Re Planning Application 2024/90421 31 Crosland Edge, Meltham HD9 5RS.

Further to the above planning application, please record an objection to the proposal on the following basis:

ELEVATION / SITE SECTION CC_
AS PROPOSED_
Scale_ 1.100

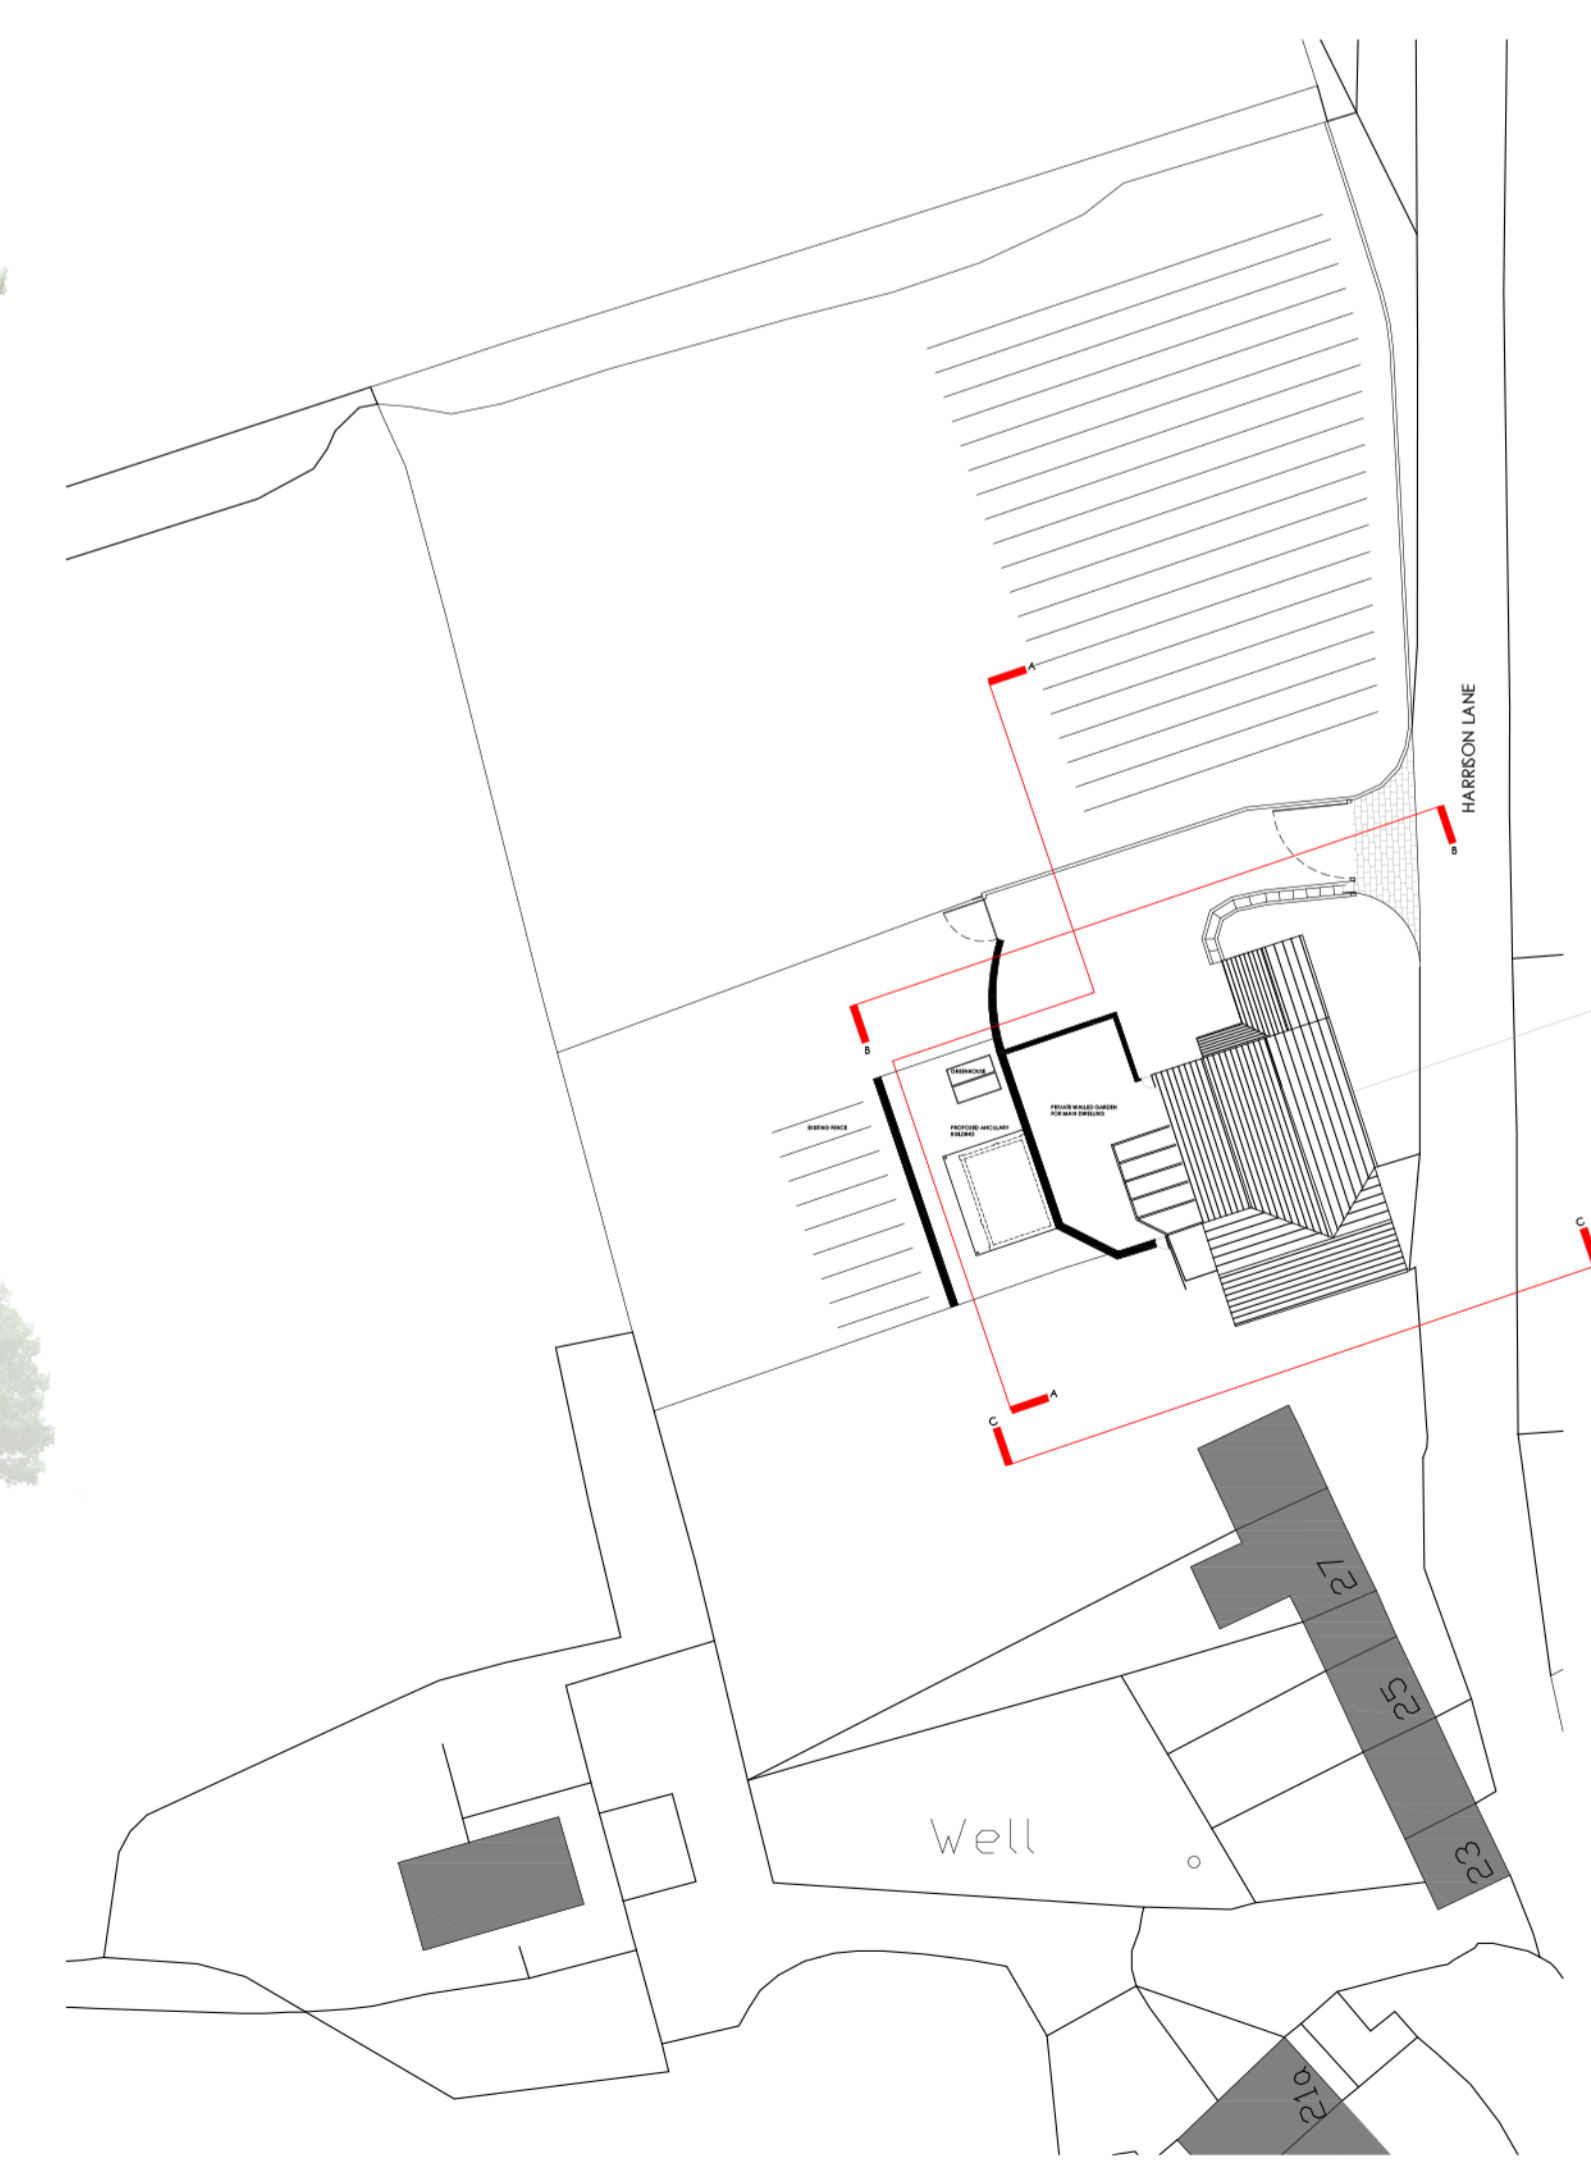
- The submission makes much of the development not visible to the host and protecting its privacy. However, it will be visible to neighbours (look at the site photographs) and anyone looking across to the prominent hillside where it and the car parking will also be seen. The size and location are inappropriate for its primary use, the consumption of alcohol.

- The sketches provided do not reflect the actual site; neighbouring properties are closer than suggested. They show extensive foliage where none exists; where it does, it has tripled in size and scope. These give the wrong impression of the site.

Drawing Title_
AS PROPOSED_ SITE + LOCATION PLAN

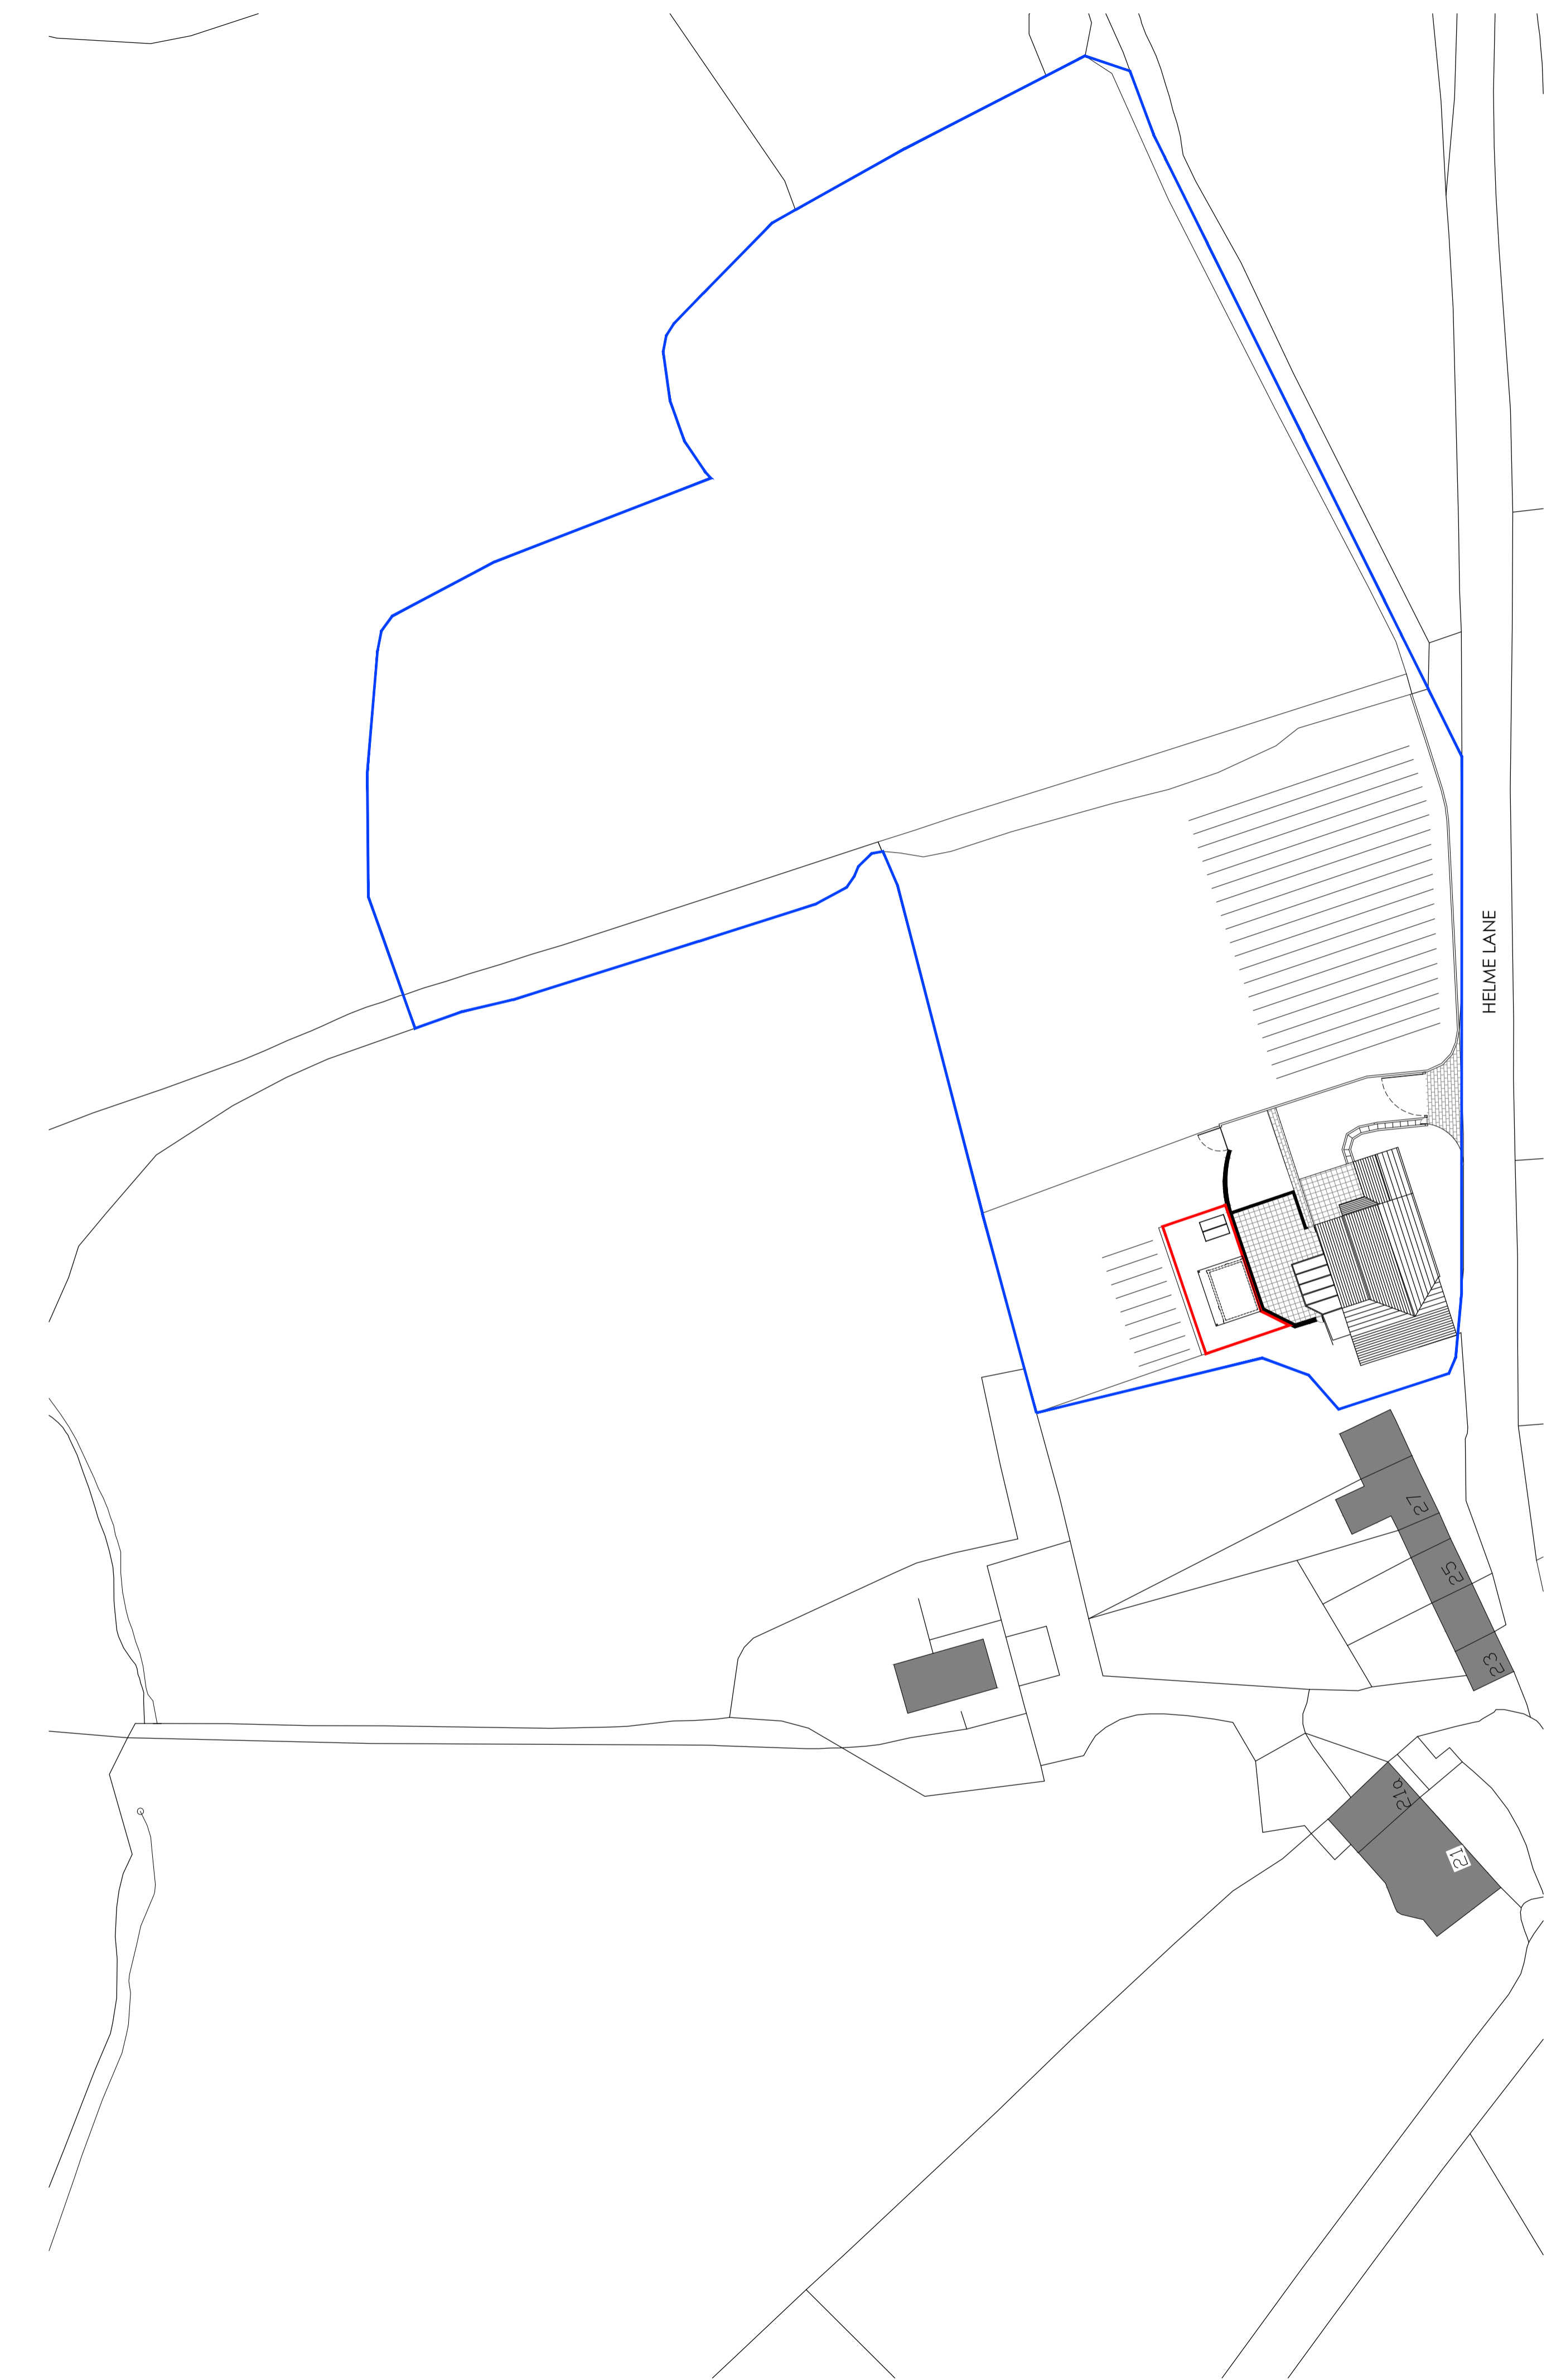
The proposed development is visible from all local public rights of way, public highways, the conservation village of Helme, and the Blackmoorfoot reservoir. It dominates the valley and cannot be called sensitive in location, size, or design. The proposed elevated parking is also as visible and impacts existing views. Harrison Lane already suffers from increased traffic following recent developments, with a particular bottleneck on route to the location. Increased traffic to this business will only exacerbate the issue.

Drawing Title_
AS PROPOSED_ FLOOR PLANS + ELEVATIONS

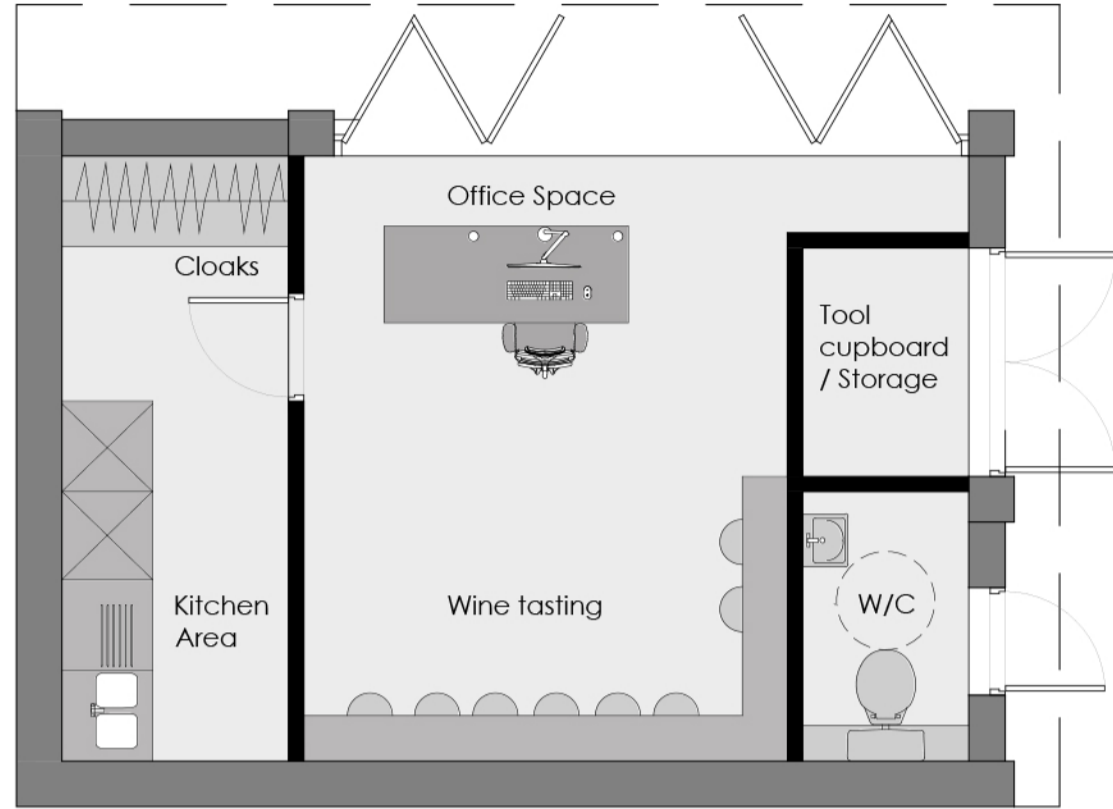
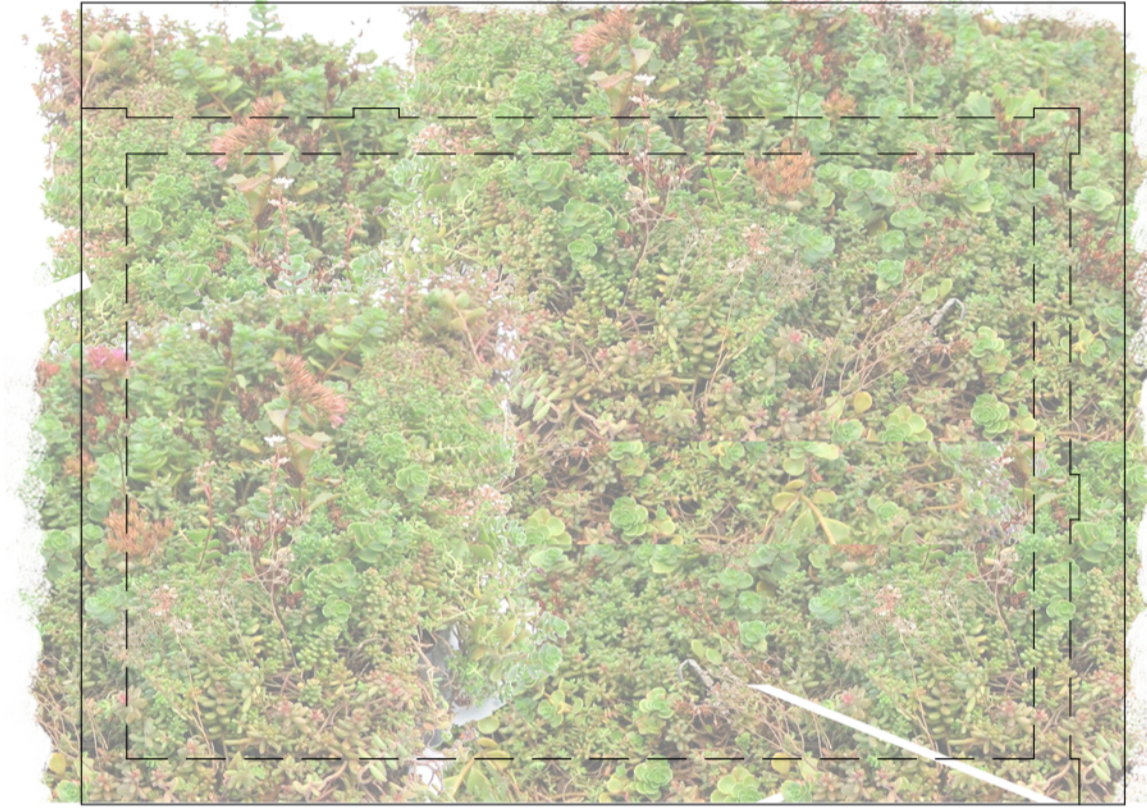
The size of the proposed facility overpowers all other agricultural structures in the surrounding fields. With the intended dimensions of 8.2 metres by 6.2 metres (almost 51 metres square) and 2.75 metres high, this is excessive in size in a greenbelt setting where no existing structure exists and will present a significant intrusion. As a comparison, this is 15 metres square greater than the footprint of a three bedroomed semi-detached home recently built in Poppy Gardens, Meltham which is currently for sale. The submissions *attempt* to reduce the impact of the scale by introducing the idea that it's "akin to a home office", but it is a home office from which a hospitality business will be based and run.

- Though the proposal speaks of a footprint of 4.6 x 6.6 meters, this doesn't include the extended canopy to two sides and gives the wrong impression of the size and its impact.

- "The purpose of the proposed canopy being unclear" is self-evident that this will be used for drinks into the evenings and in wet weather to extend the volume of tour opportunities.
